KITTTITAS COUNTY DEPARTMENT OF PUBLIC WORKS

TO: Ms. Chelsea Benner, Planner I
COPY: Ms. Taylor Gustafson, Planner III
DATE: October 8, 2018
FROM: Mark R. Cook, Director 
RE: Vantage PUD Shoreline Substantial Development Permit

I have reviewed the Shoreline permit submitted for the Vantage PUD (plat) tax parcels 622933 and 272933. My review comments appear below for your consideration.

A PORTION OF THE EAST 1/2 OF SECTION 30, TOWNSHIP 17 N., RANGE 26 E., W.M.

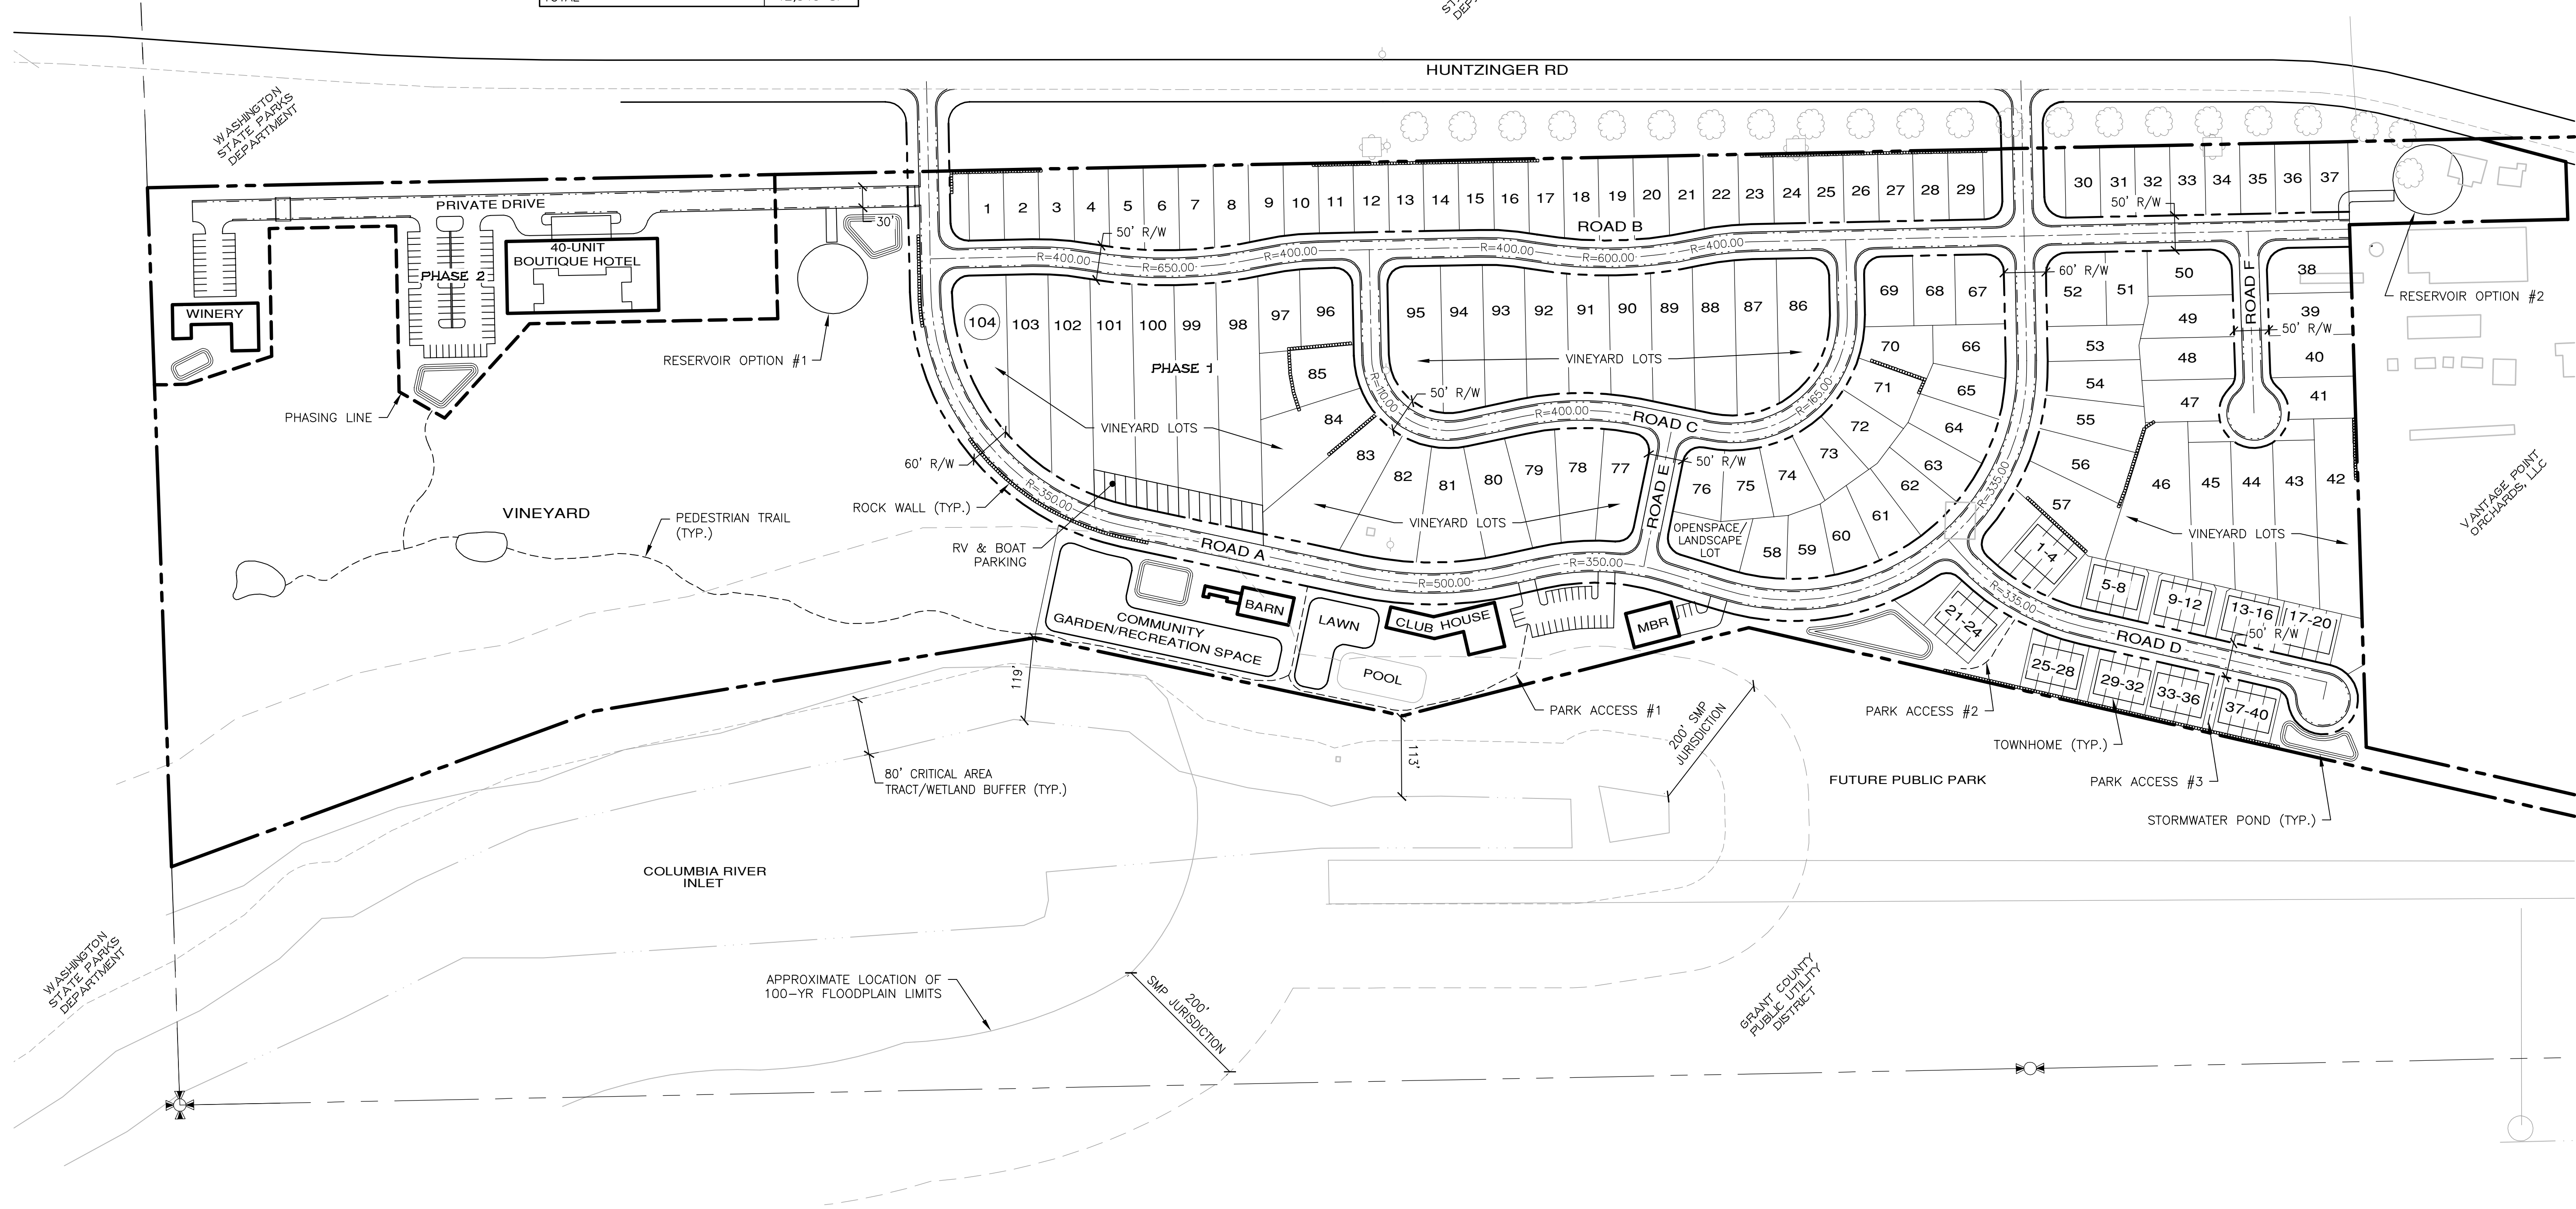
1. Permit question 23: Impervious area.

The 4,360 square feet of impervious area noted on the application is the area within the designated shoreline management area. The area is part of a larger impervious impact created by the entire plat and as such will be included in the plat final stormwater plan. Given the proximity of the proposed stormwater management area relative to the shoreline, the applicant is reminded of Ordinance 2006-60 condition no. 13 as it relates to additional monitoring requirements:

Public Works may be able to work with the proponent's engineer devising a stormwater scheme to minimize or negate the need for above referenced monitoring requirement – during final stormwater plan submittal.
